**KIRKLEES METROPOLITAN COUNCIL
INVESTMENT & REGENERATION SERVICE**

**DELEGATED DECISION TO DETERMINE APPLICATIONS FOR
CONSENT, AGREEMENT OR APPROVAL REQUIRED BY CONDITION**

Reference No:	2024/44/92428/W
Site Address:	Land at, Penistone Road, Fenay Bridge, Huddersfield, HD8 0AW
Description:	Discharge of details reserved by condition 28 (materials) of previous permission 2022/93154 for erection of 68 dwellings with associated access, parking, open space, landscaping and infrastructure works (including installation of surface water attenuation tank)
Recommending Officer:	Nick Hirst

DECISION – Discharge of Condition – Approve

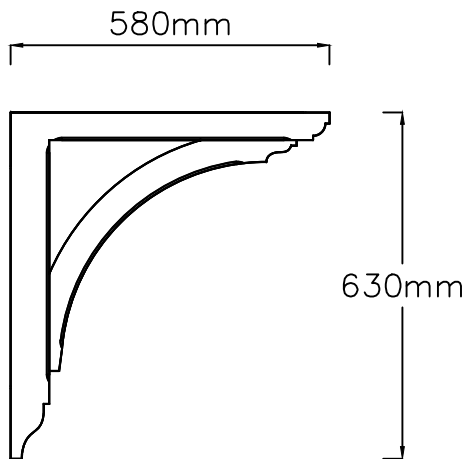
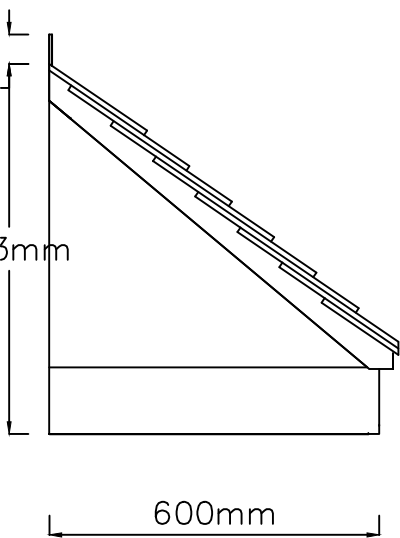
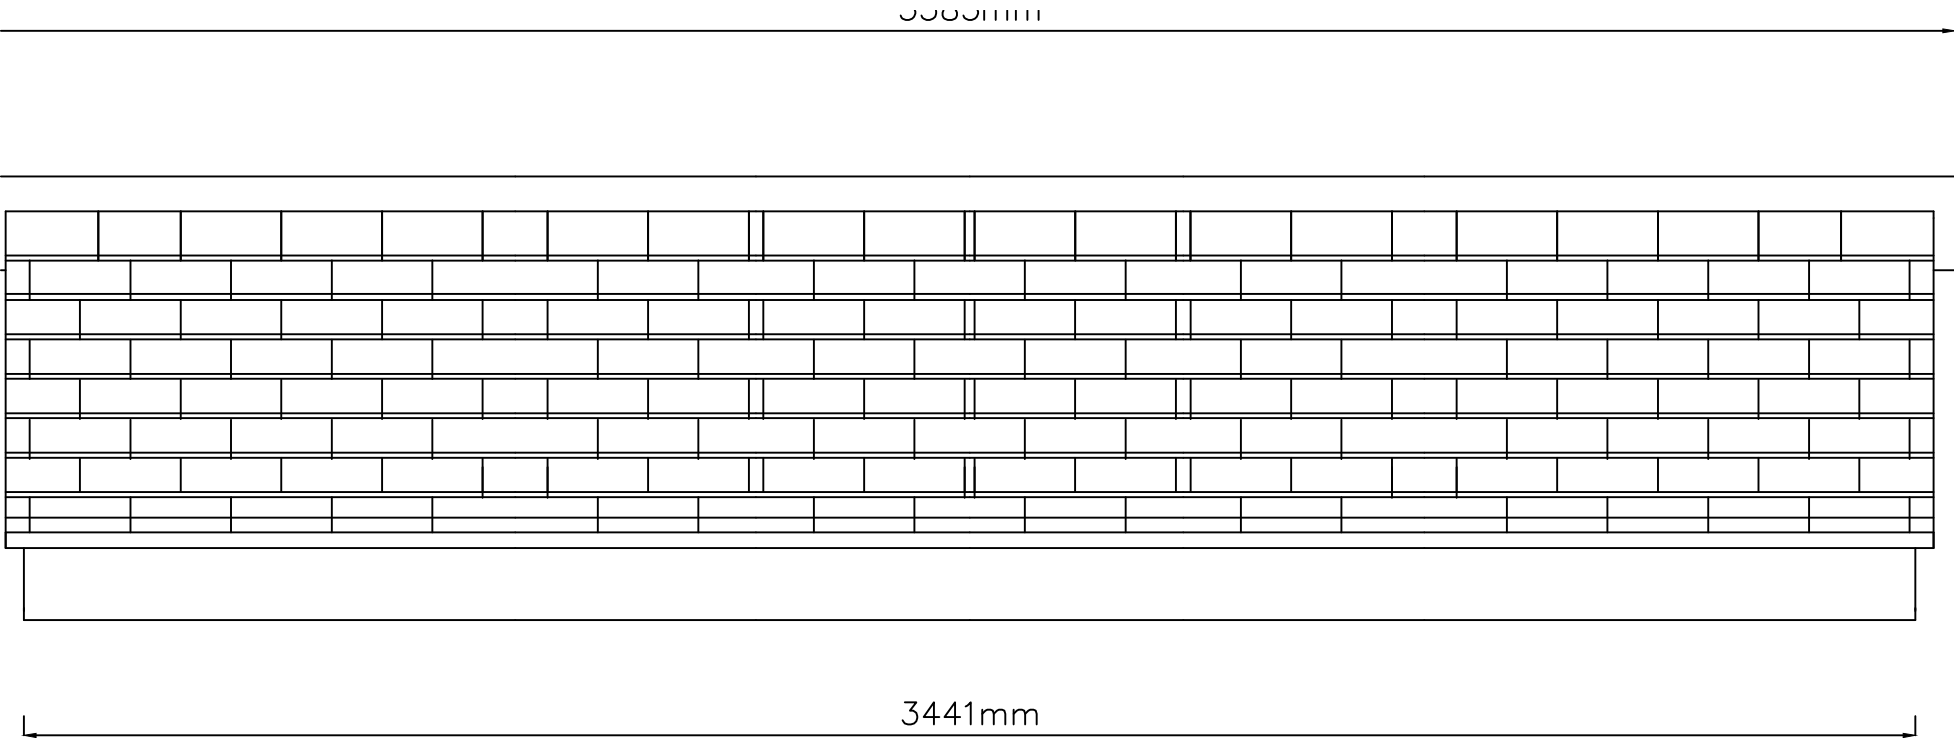
Typical sections and plans for the proposed canopies have been provided. These are shown to have traditional designs, being pitched and not flat, as expected at application stage. Attractive decorative brackets to support the canopies, where needed, are proposed. Overall, the details shown are considered acceptable.

PROJECT: Standard Details 2023 Issue			
DRAWING TITLE: Window Elevations

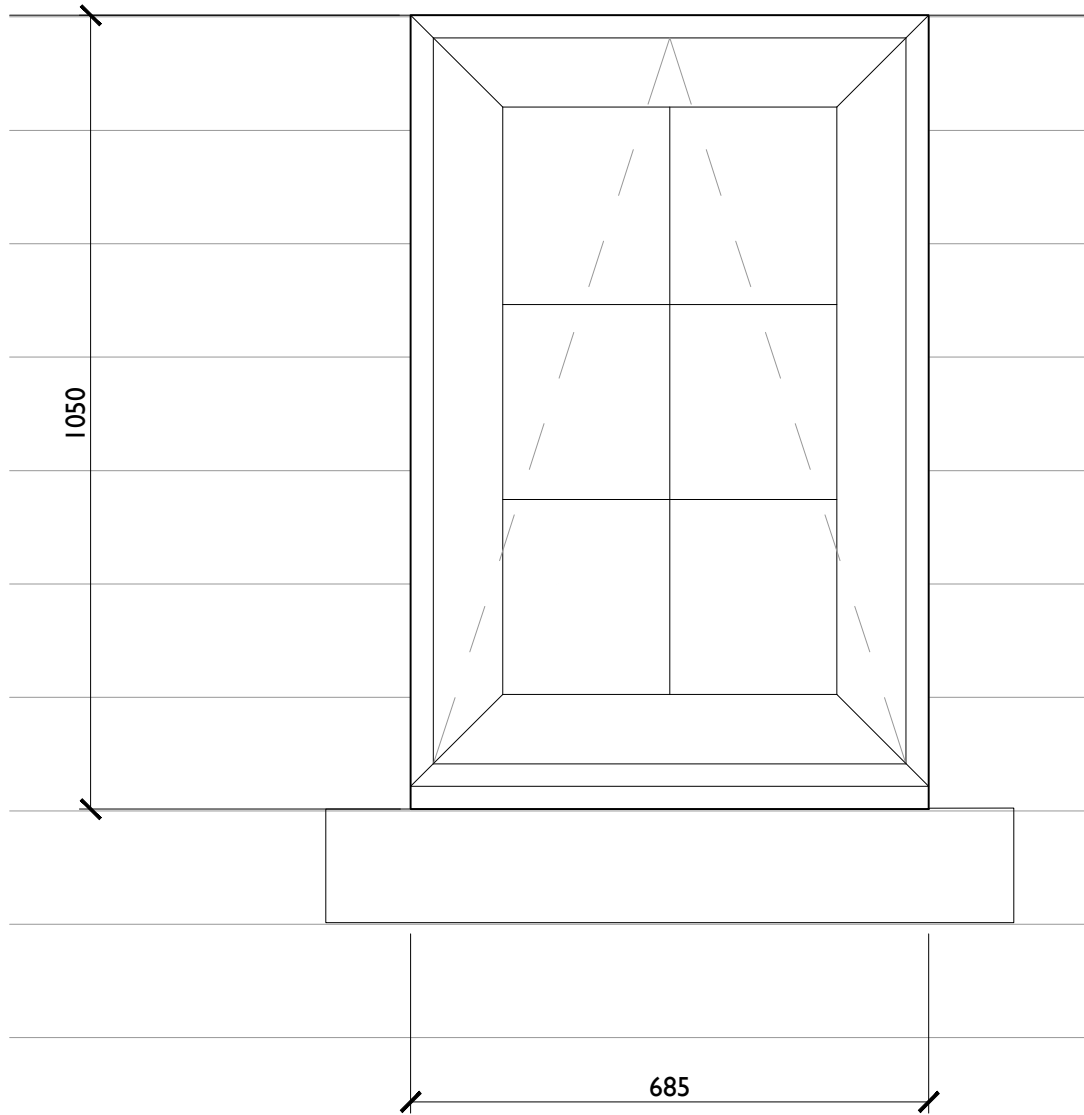
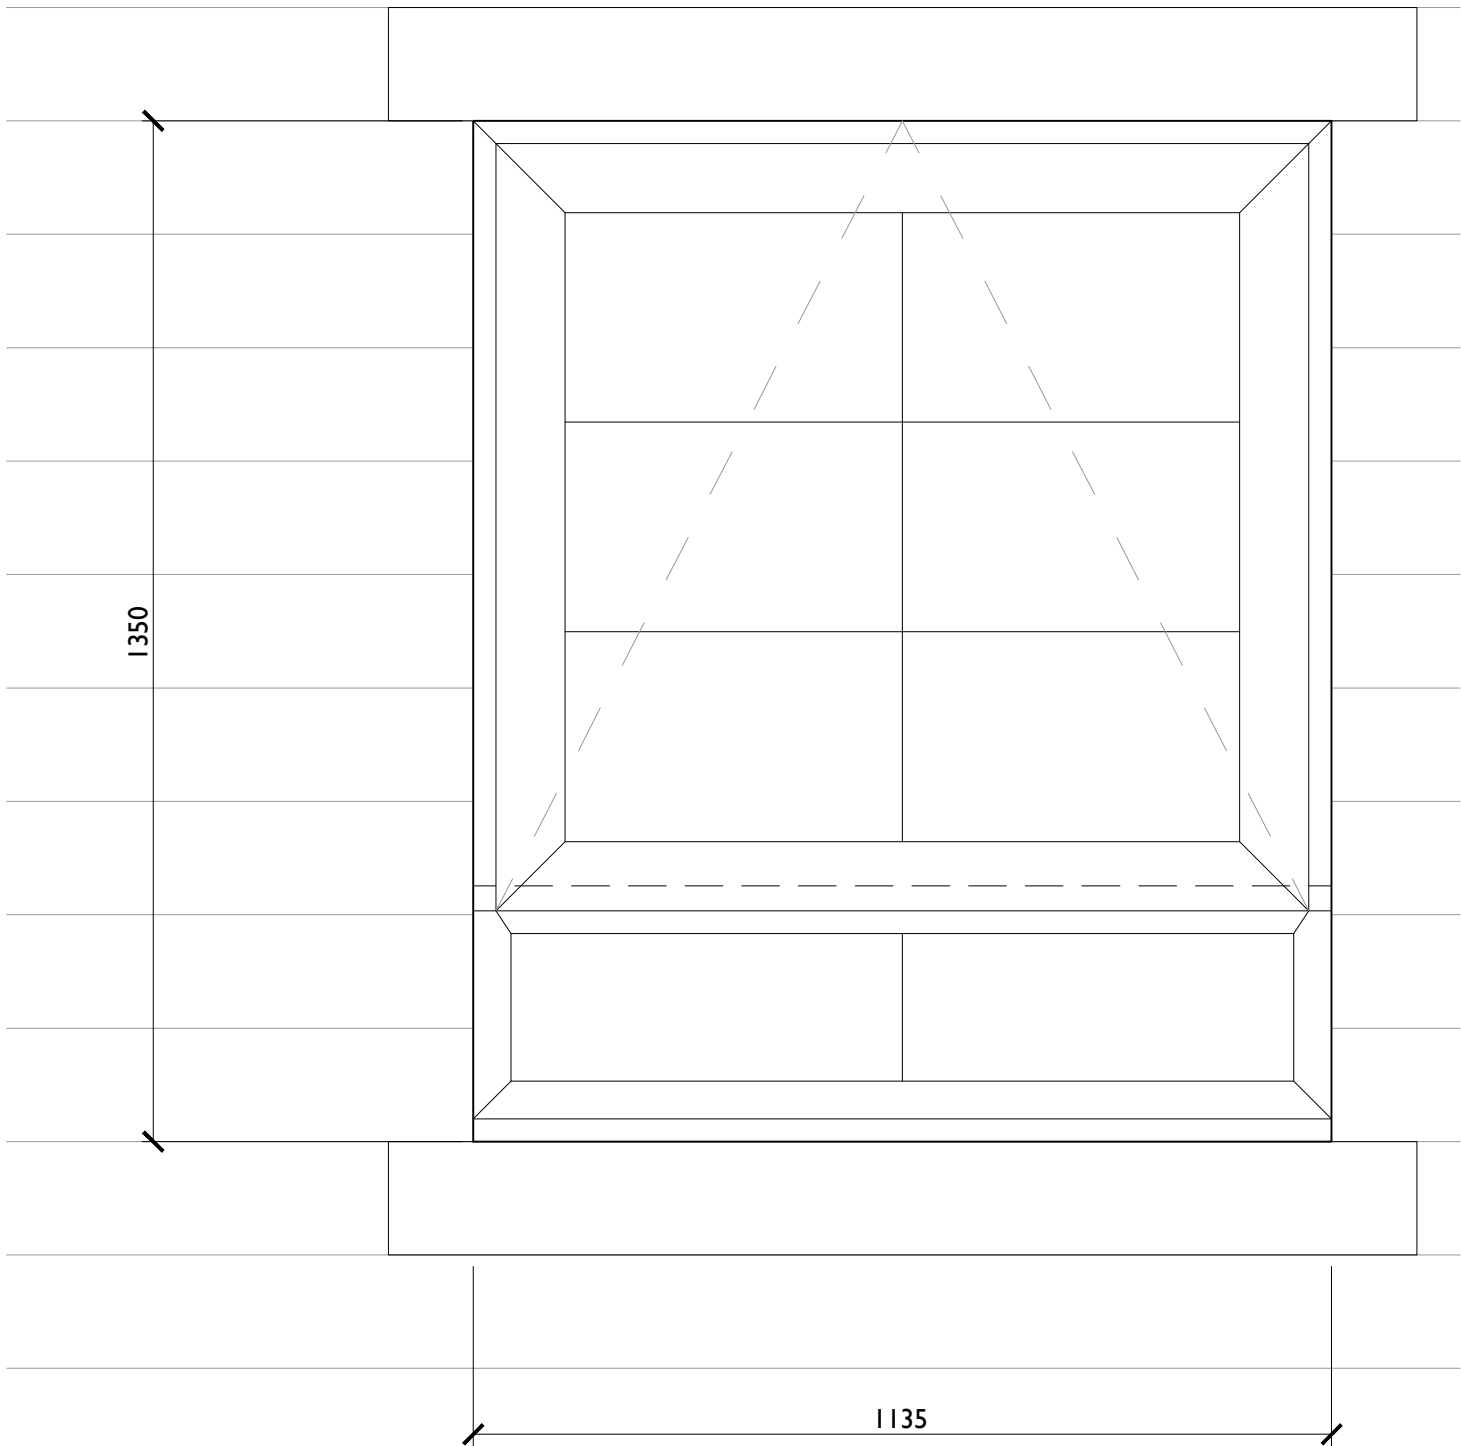
Typical window section details have been provided and are acceptable. Windows are shown to have a minimum 75mm reveal, as required by the condition.

DRAWING TITLE:	Independantl Lintel Detail Brick Head
----------------	---------------------------------------

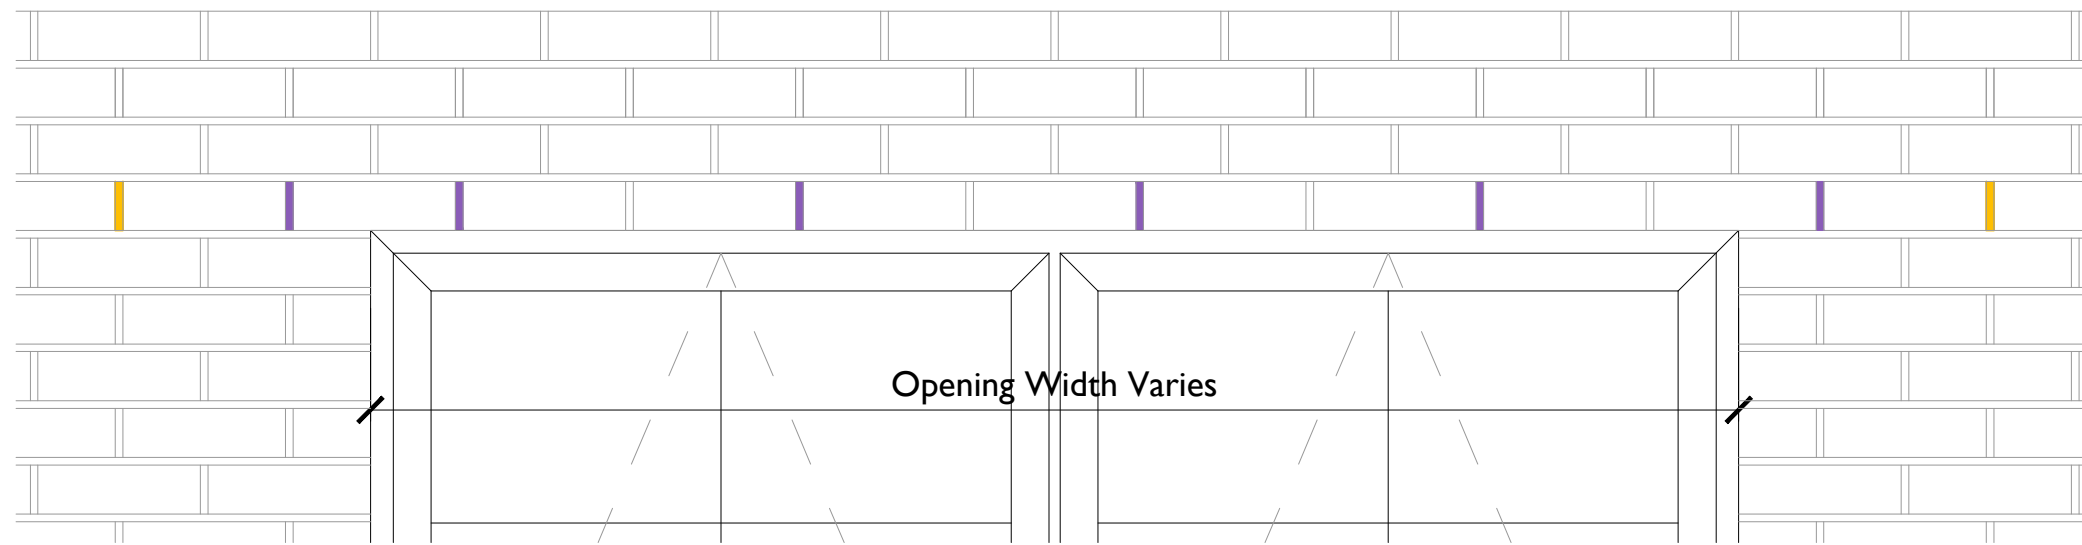
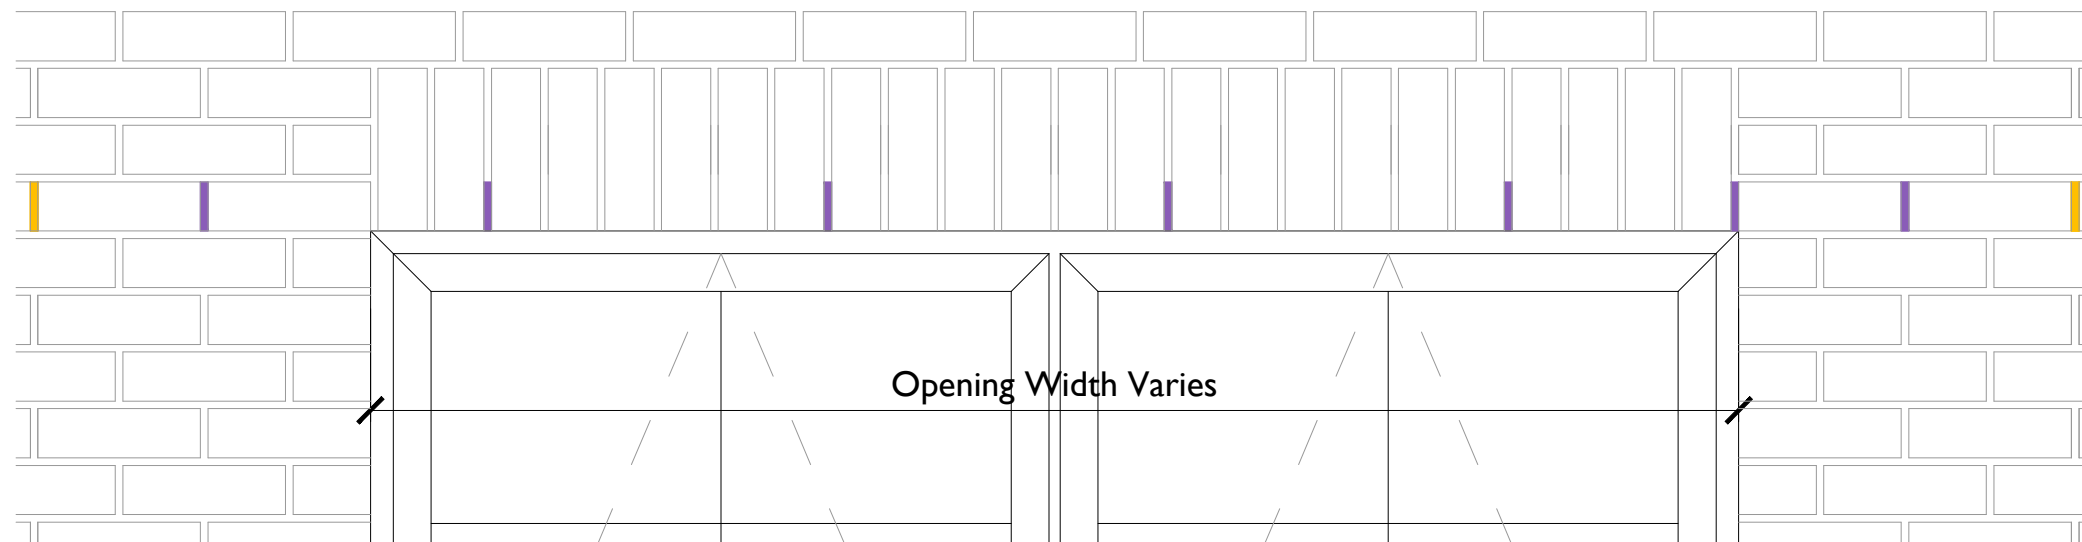
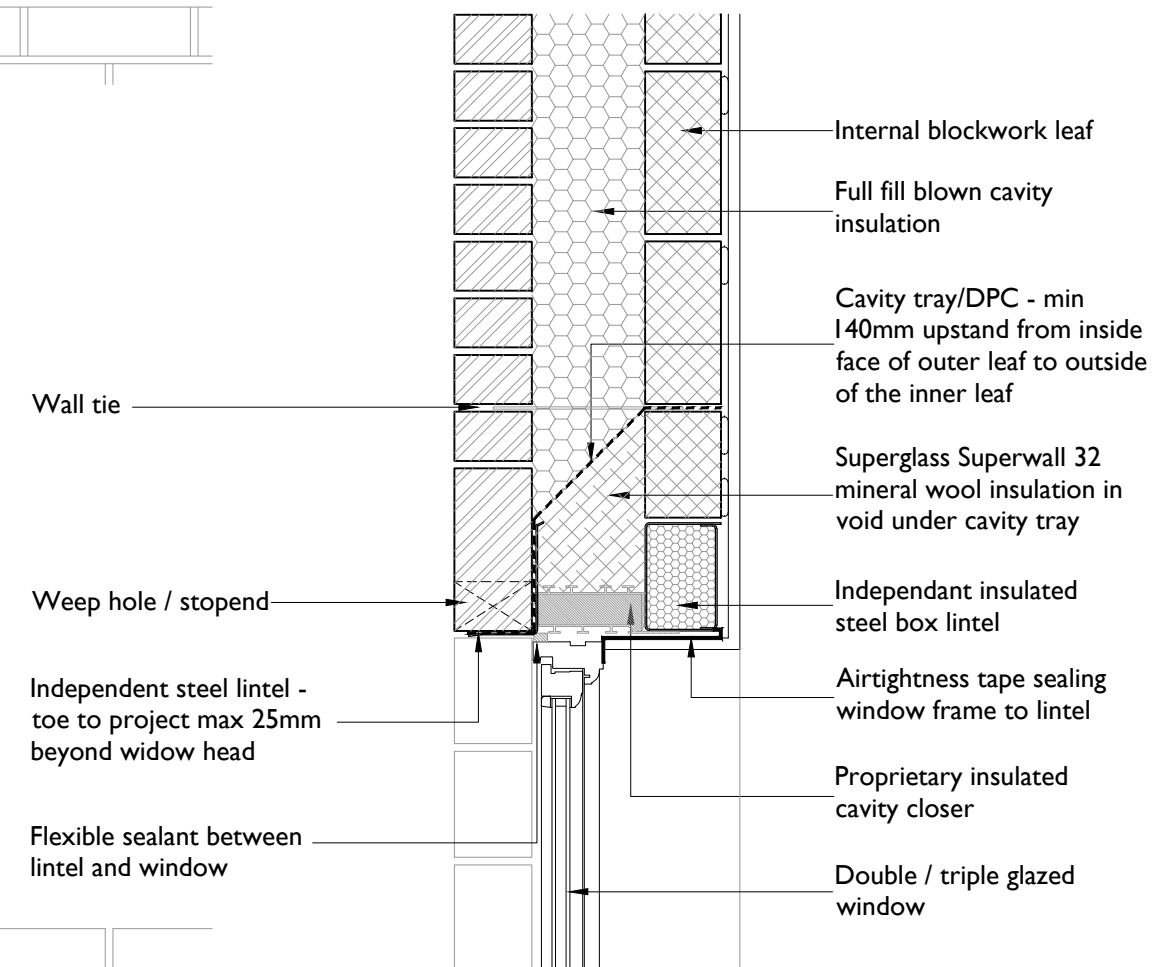
Heads and cills are to be an ashlar artstone in the colour “bathstone”. This would be pale in appearance, similar to local ashlar products. Officers consider that it would suitably complement the main walling materials considered above.
